Response to SSD-79307746 application: Flood Addendum, Central Precinct

To: Sam Hui (WL Developer Pty Ltd)
From: Carlos Figueroa (WSP Water Resource Engineer)
Michele Zornitta (WSP Technical Executive)
Subject: **Environmental Impact Statement – Waterloo Metro Quarter – Central Precinct (SSD-79307746)**
Our ref: PS219170-HYD-MEM0WMQN-Rev1
Date: **13 March 2026**

This flood addendum has been prepared to respond to the comments provided by the Department of Planning, Housing and Infrastructure and the Conservation Programs, Heritage and Regulation Group associated with the Waterloo Metro Quarter Central Precinct (SSD-79307746).

OVERALL ARRANGEMENT - GROUND FLOOR

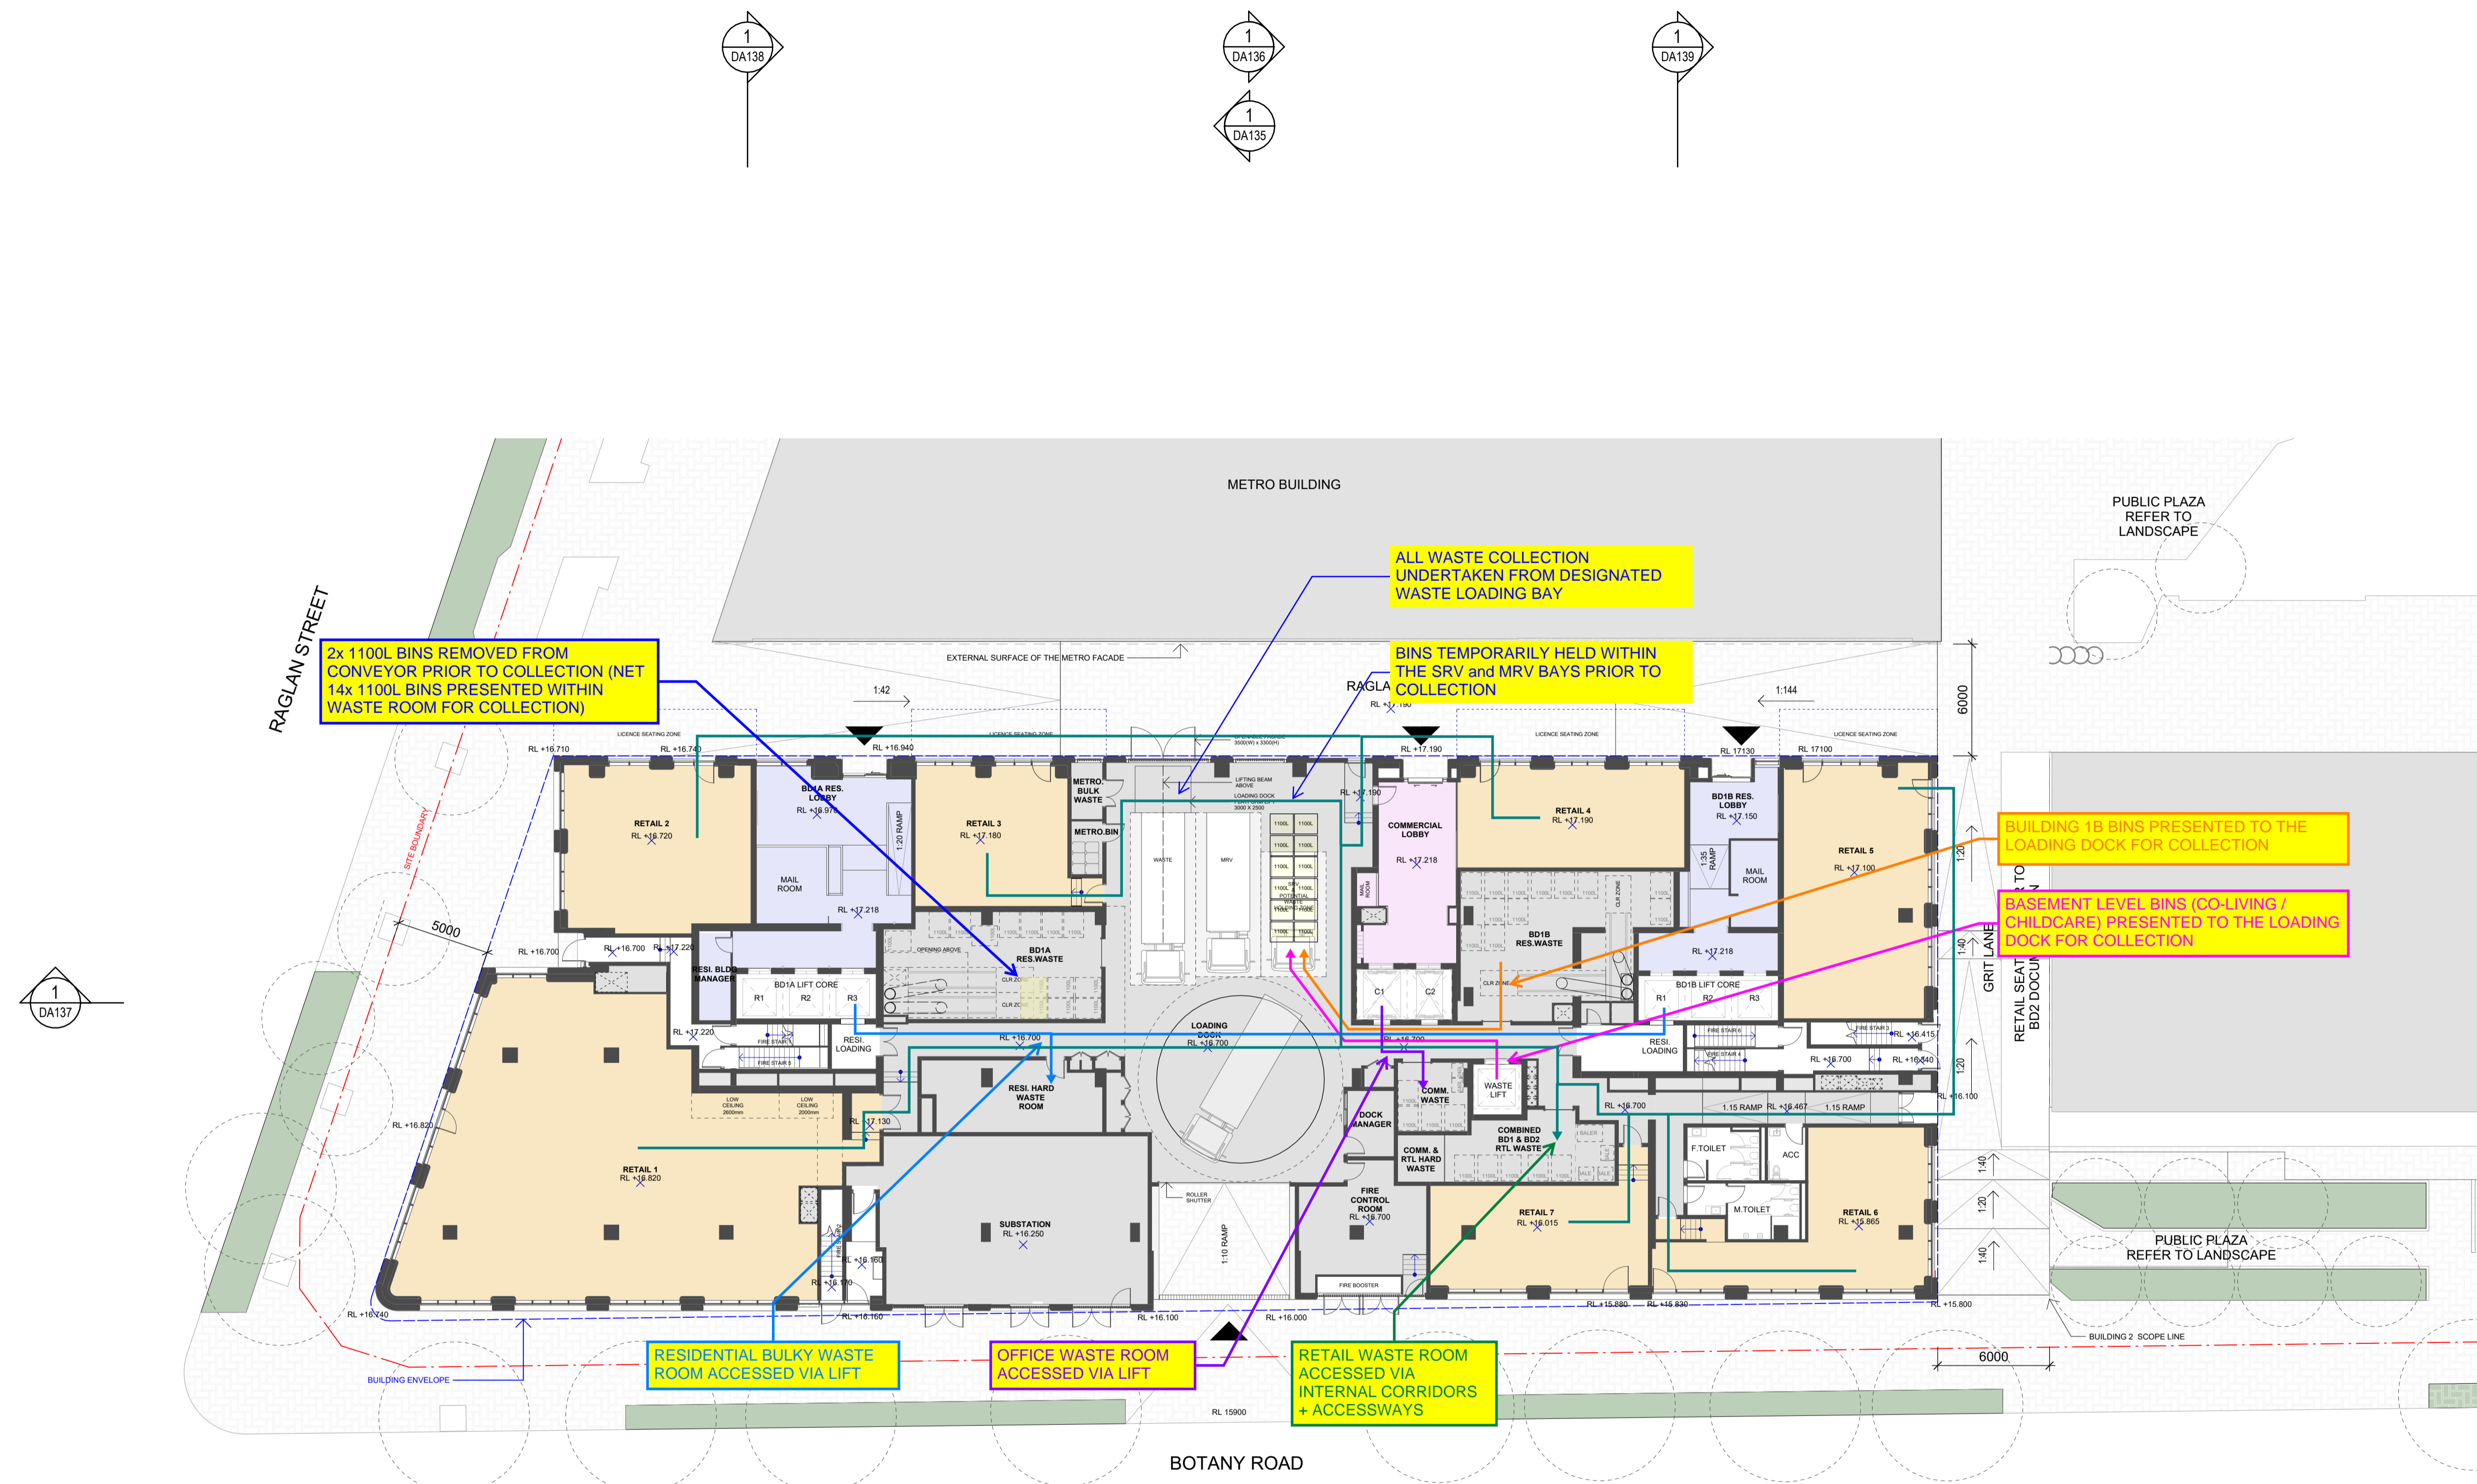
The floor level of Retail Area 3, located in the south-eastern part of the ground floor, as identified in the Central Precinct FIA page 46, has freeboard to the 1% Annual Exceedance Probability (AEP) flood level and is below the Probable Maximum Flood (PMF) level.

CPHR notes that Retail Area 3 may not have sufficient warning time to allow for safe relocation to on-site shelter. Internal access to a refuge area should be provided or the floor level raised to be above the PMF level. It should be demonstrated how occupants could feasibly relocate to higher levels considering available warning time and mechanisms to provide warnings.

1. The proposed design incorporates a podium that raises the ground level along Botany Road and Church Square corner adjacent to the Congregational Church. The raised Finished Floor Level (FFL) of RL 16.000m AHD provides Retail Area 3 with protection from a 1% AEP flood. To address flood resilience requirements for the Probable Maximum Flood (PMF) level, Retail Area 3 has been provided with a dedicated evacuation exit providing direct egress to Church Lane, which is situated above the PMF level. This evacuation route has an FFL of RL 16.500m AHD, ensuring that occupants can safely relocate to higher ground during extreme flood events.

2. Figure 1 illustrates the designated evacuation routes from Retail Area 3 to areas located above the PMF level and towards internal refuge areas. The Central Precinct Flood Emergency Response Plan (refer to Appendix 1) will provide detailed procedures for occupant evacuation, including warning mechanisms, communication protocols, and expected warning timeframes.

3. Current flood modelling indicates an estimated time to peak flood level of approximately one hour. Warning systems will be put in place and activated by a severe thunderstorm warning with reference to flash flooding to ensure a reasonable window for safe evacuation. Warning systems for the site are further described in Central Precinct Flood Emergency Response Plan.

OVERALL ARRANGEMENT - LEVEL 1

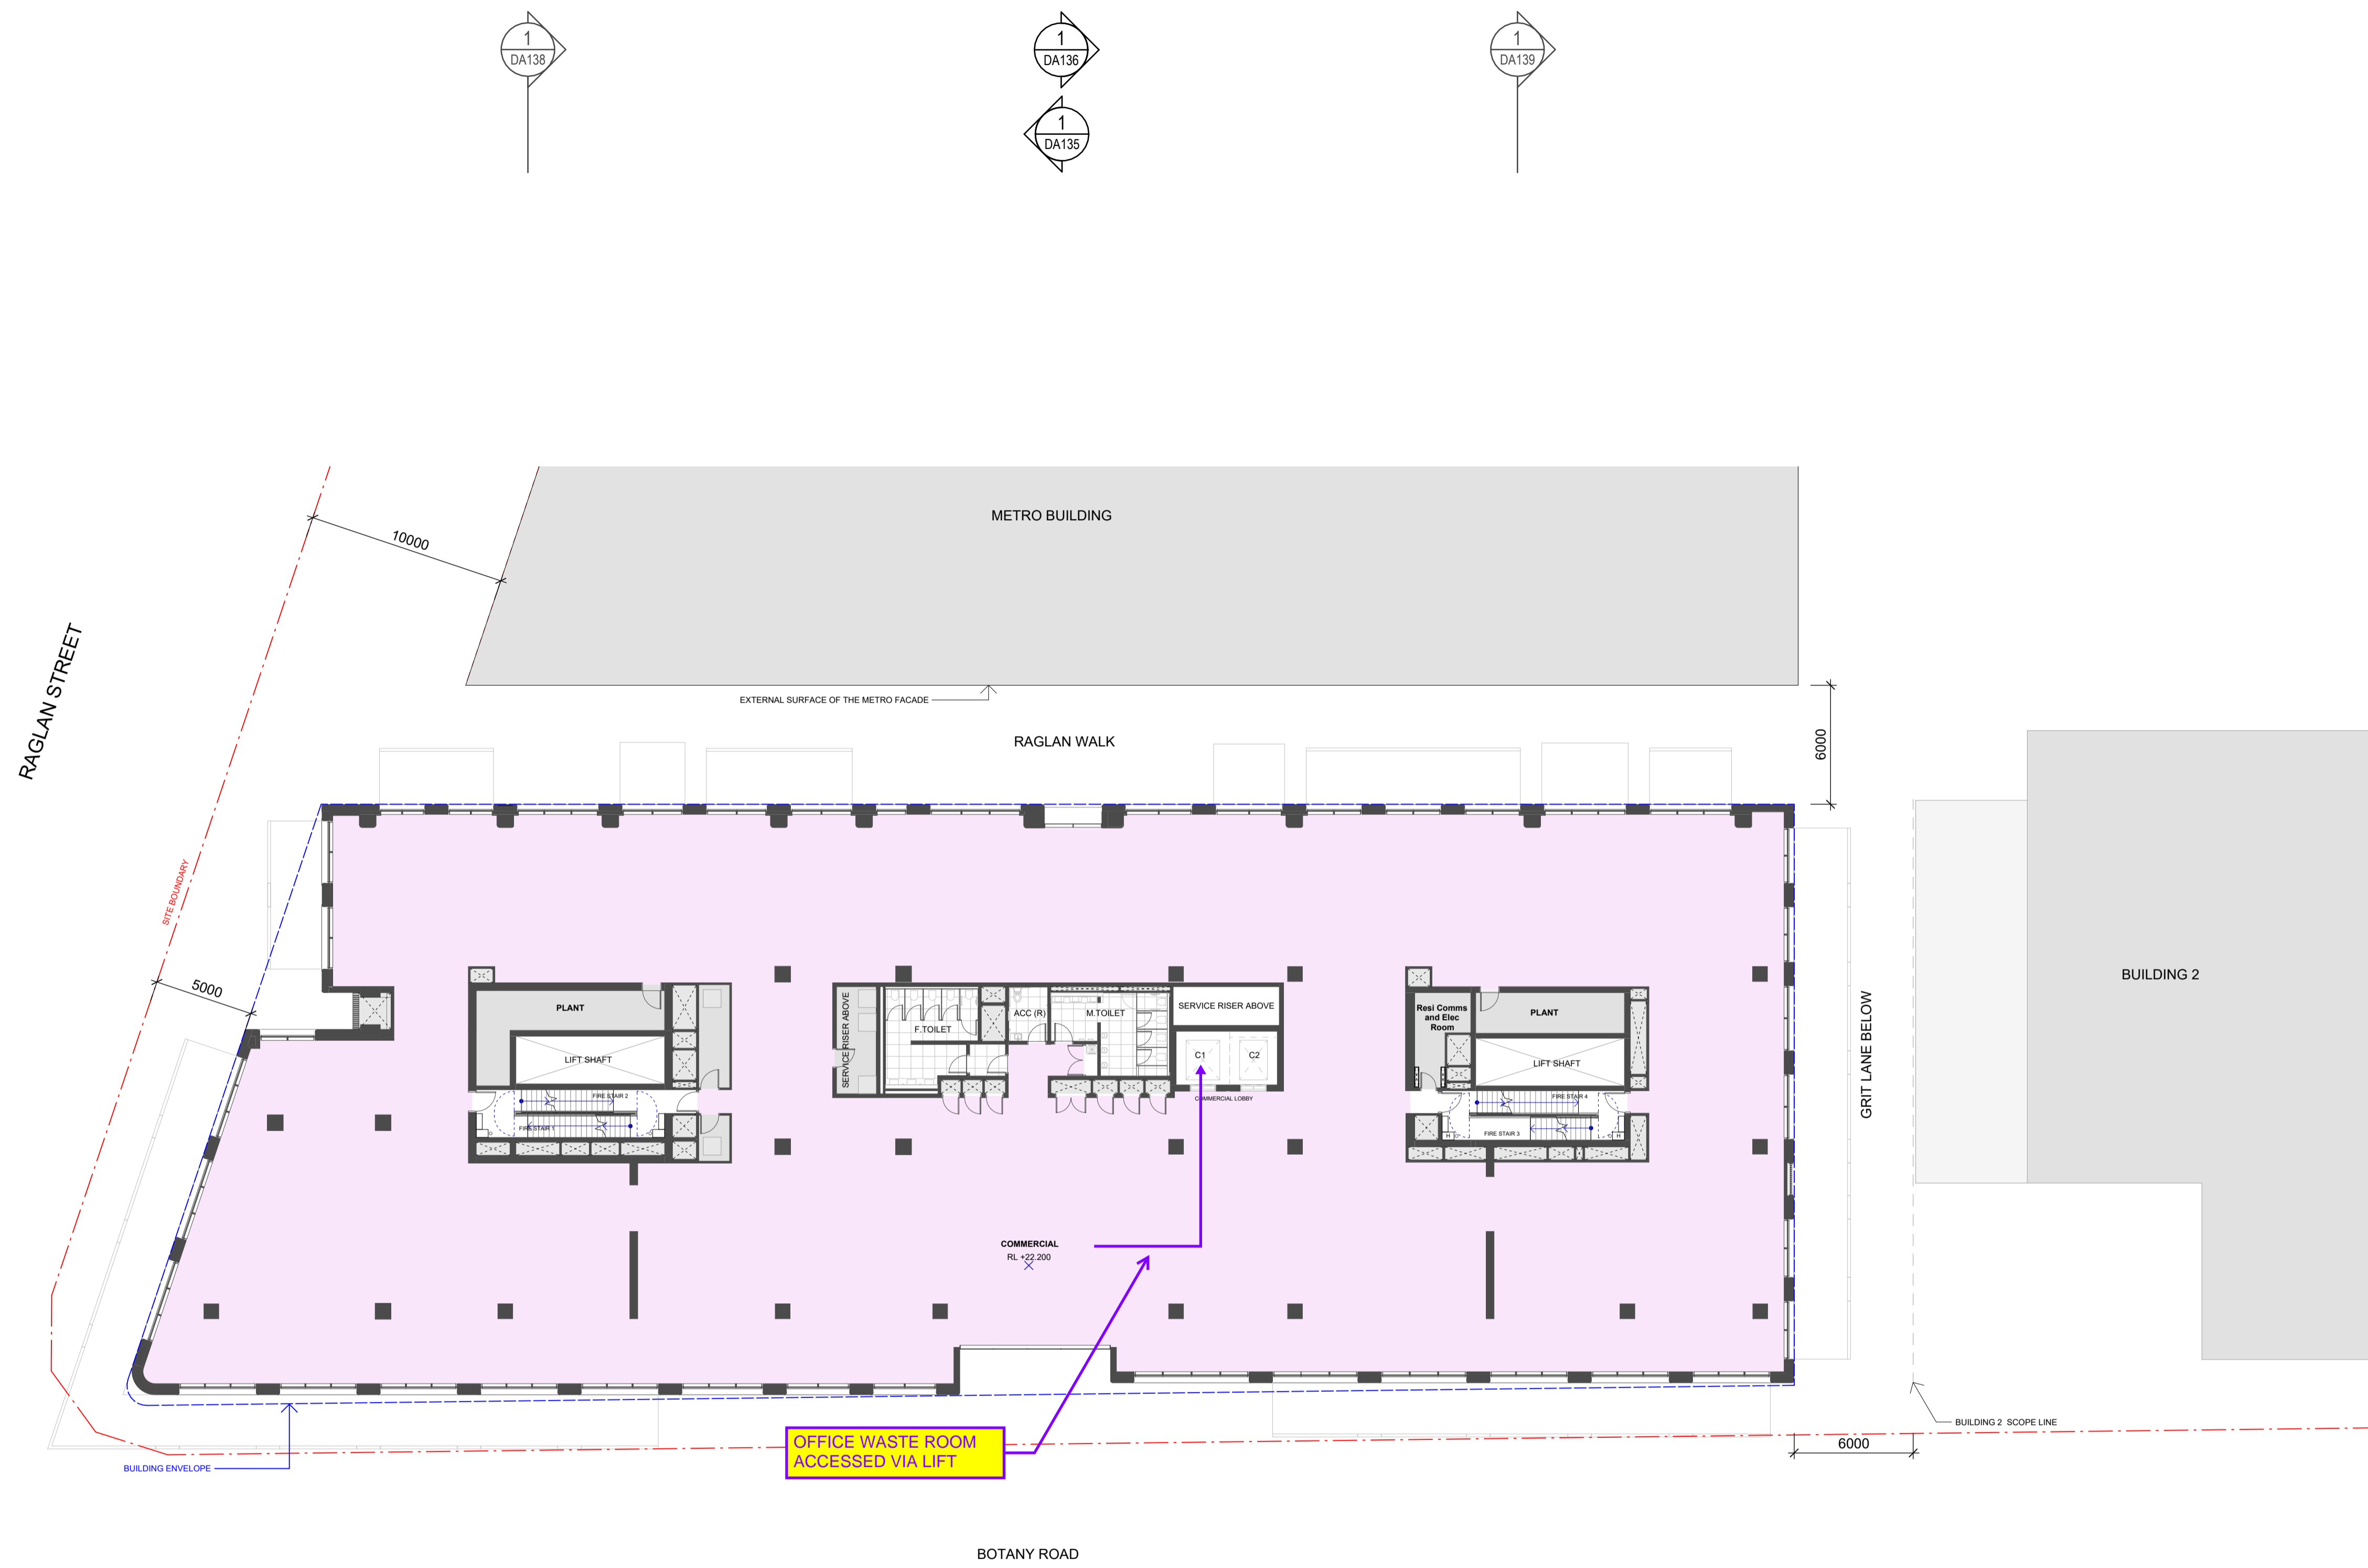
A childcare centre is proposed in an area surrounded by flooding greater than 1m in the PMF. The emergency management approach for the childcare centre should be considered in consultation with the NSW State Emergency Service (SES).

6. As noted in the CPHR submission, the Childcare Centre Lobby is located on a podium level that becomes surrounded by floodwaters during a PMF event. However, the lobby entrance is set at RL 16.600 m AHD, which is 158 mm above the PMF flood level.

- a) Under the PMF scenario, the maximum water depth in front of the childcare lobby is estimated to be 110 mm remaining below the proposed finished floor level. Accordingly, occupants within the Childcare Centre Lobby are protected from flooding for events up to and including the PMF. In extreme flood events, occupants are able to utilise the internal stairs to take refuge on Level 1 (refer to Figure 2).
